20170038.4/1005A/R1/TA

Western Sydney Stadium (Project No 255417) - Stage 2 DA - Response to EPA & DOP

This letter presents a response to queries raised by the NSW Environmental Protection Authority and Department of Planning in letters dated 7 April 2017 and 13 April 2017 respectively.

1.1 EPA COMMENTS – LETTER EF16/2911, DOC152571-01

$L_{max}$   
in dB(A)

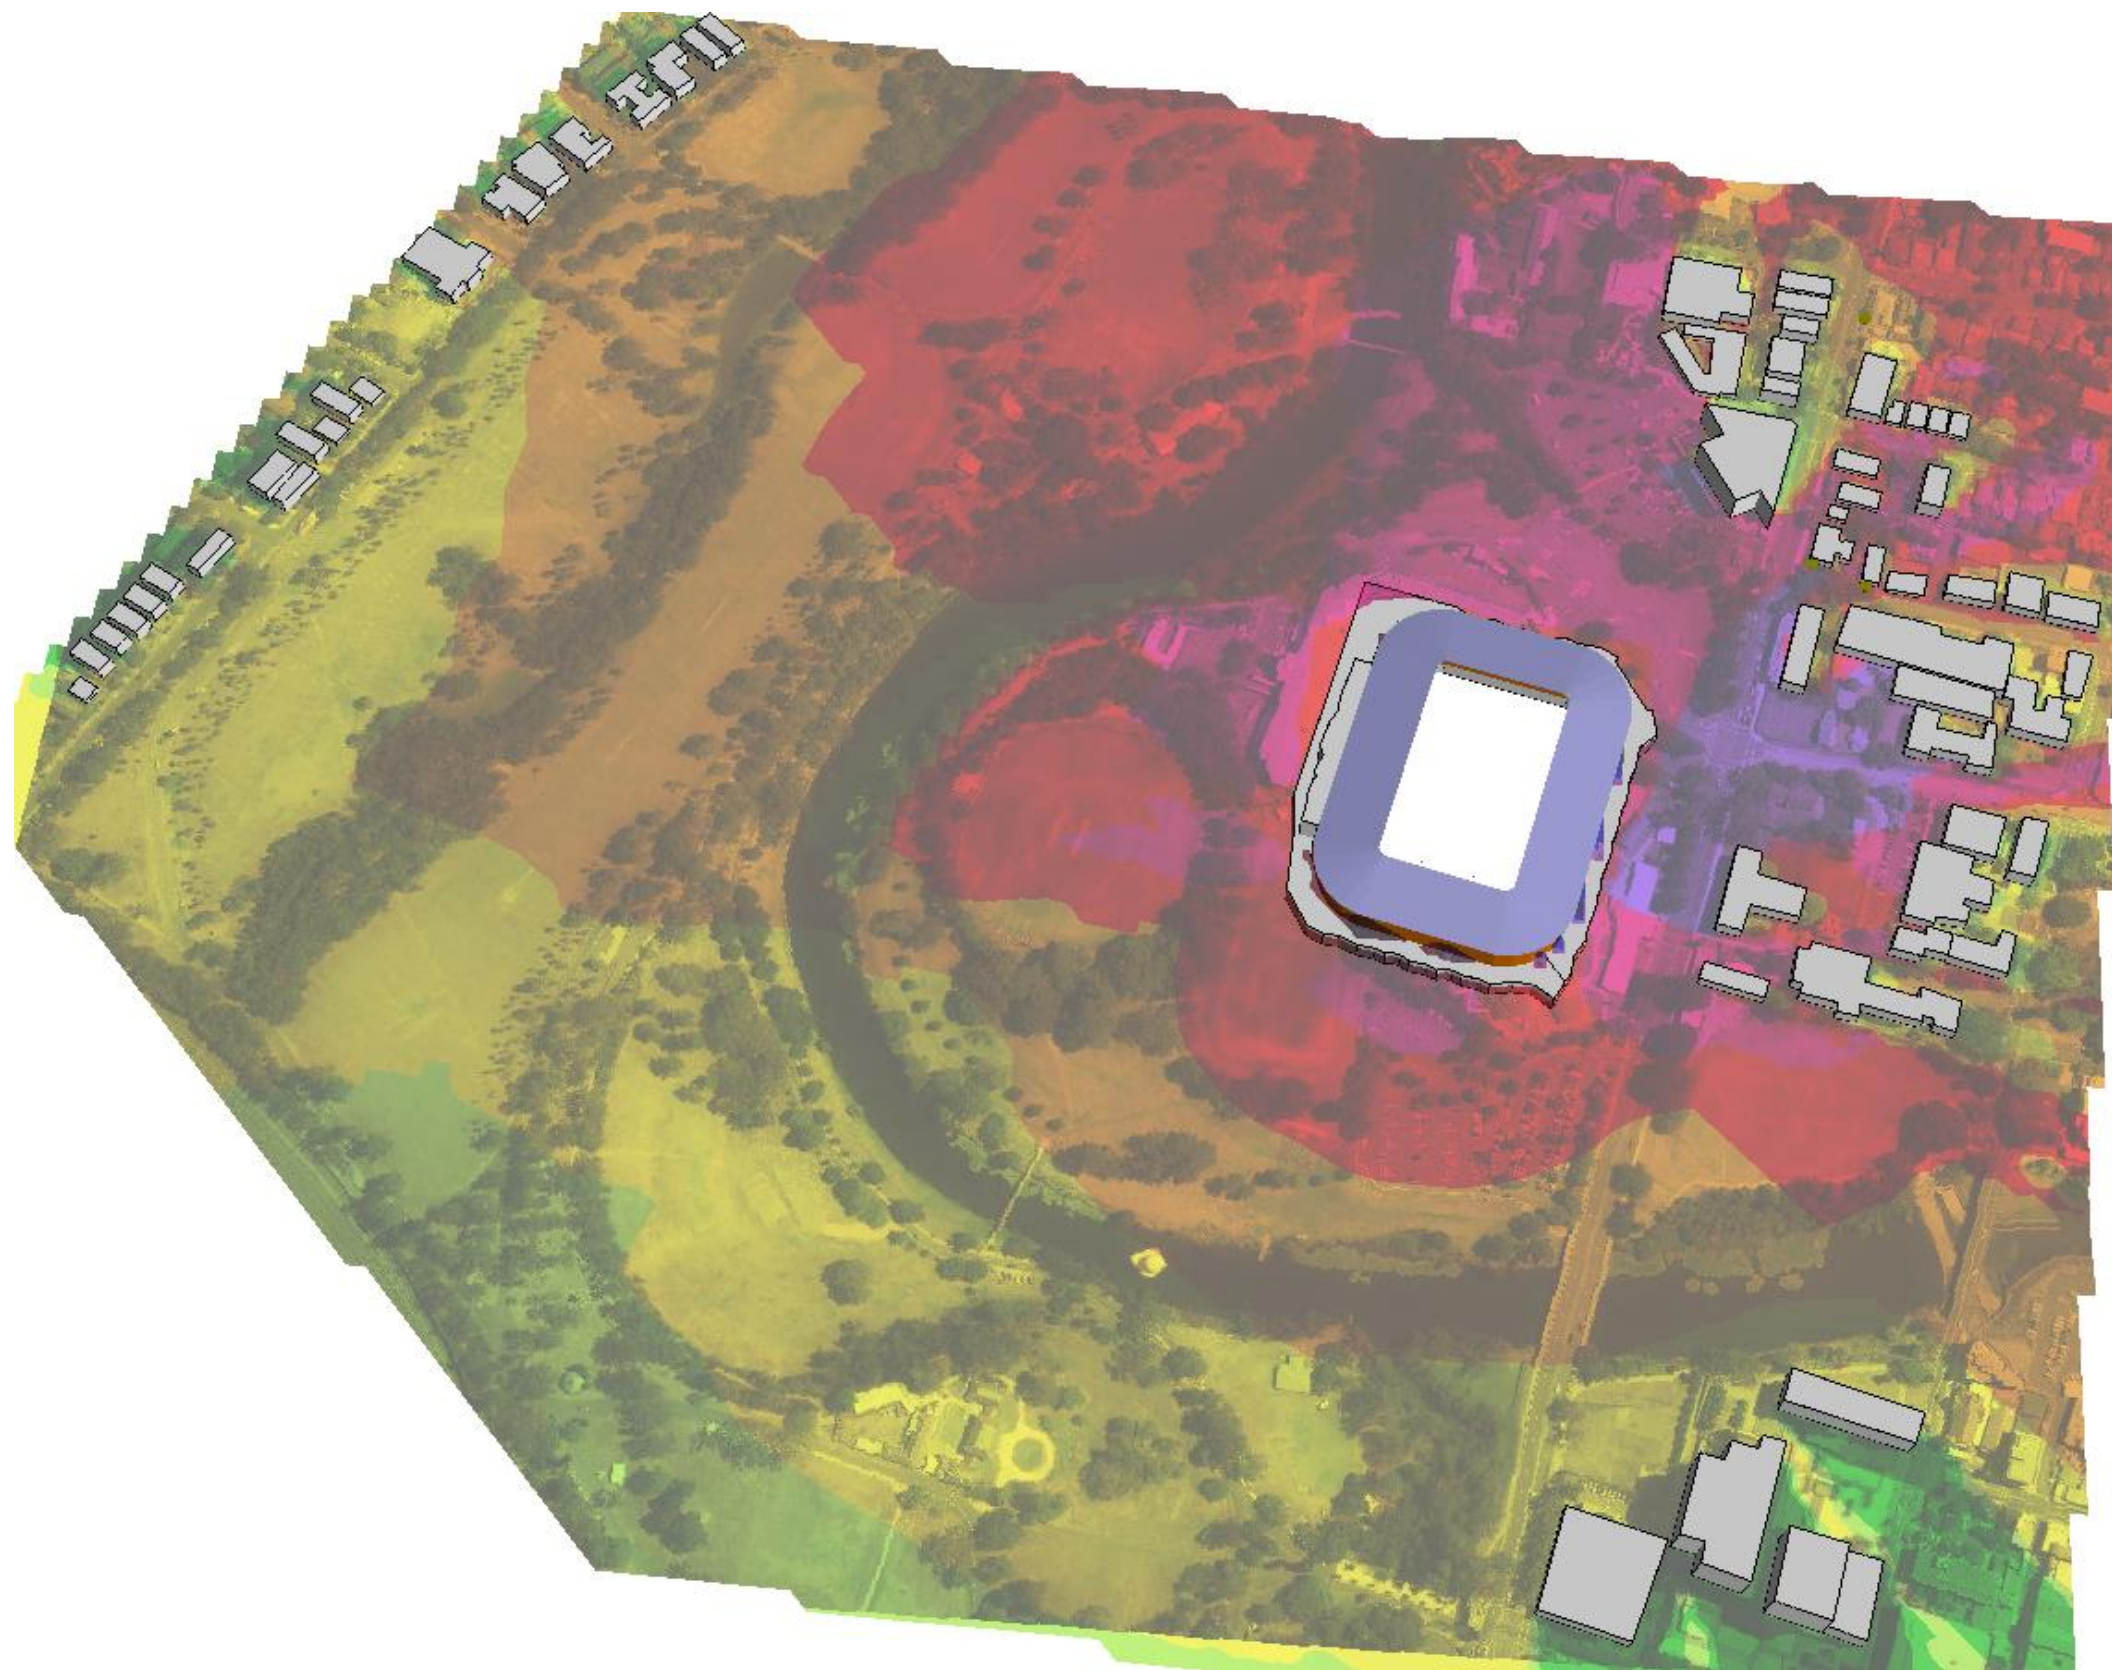
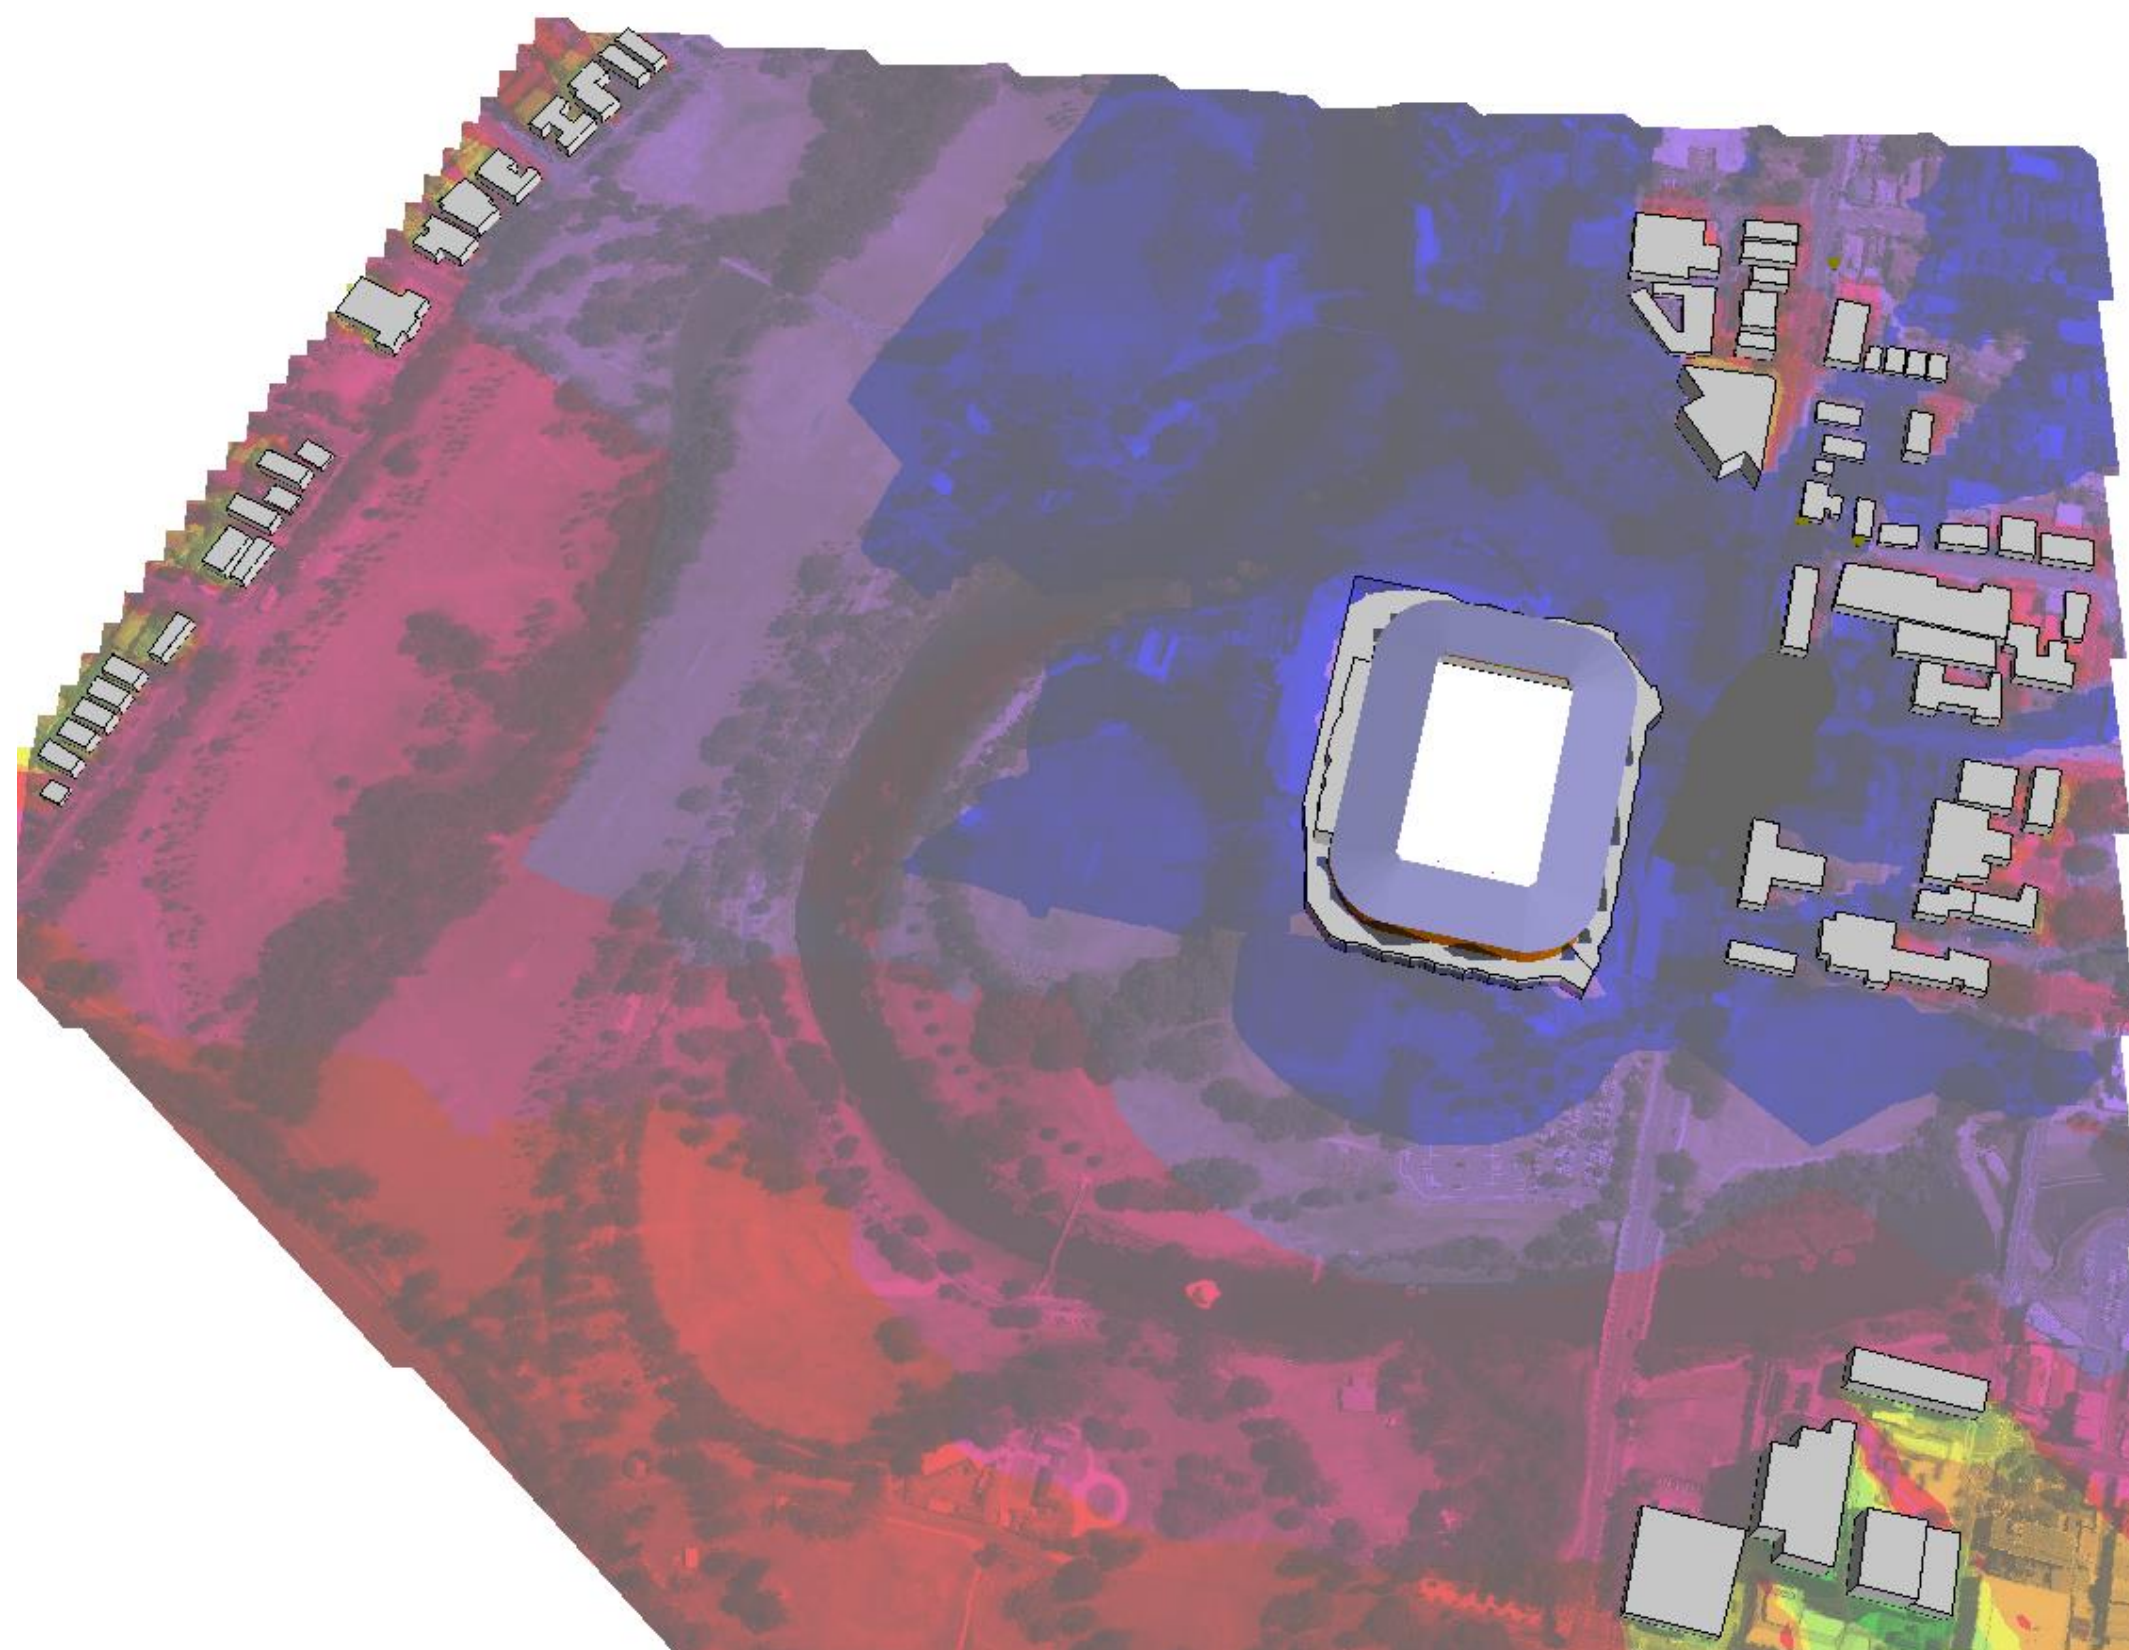
- (a) tabulated data using the various recommended A and C weighted noise descriptors required to facilitate proper evaluation of those predicted noise impacts, and
- (b) details of predicted day-time noise impacts on non-residential noise sensitive land uses, including local schools, the nearby child care facility and the nearby place of public worship (St Patricks Cathedral).

The impacts on all land uses are detailed in the requested "*marked up orthophoto maps showing the predicted noise levels contours for various proposed activities*"

The predicted daytime noise levels for events are the same as the night time events, as ultimate noise levels from concerts, crowds, sporting events, etc are not dictated by the ambient environment.
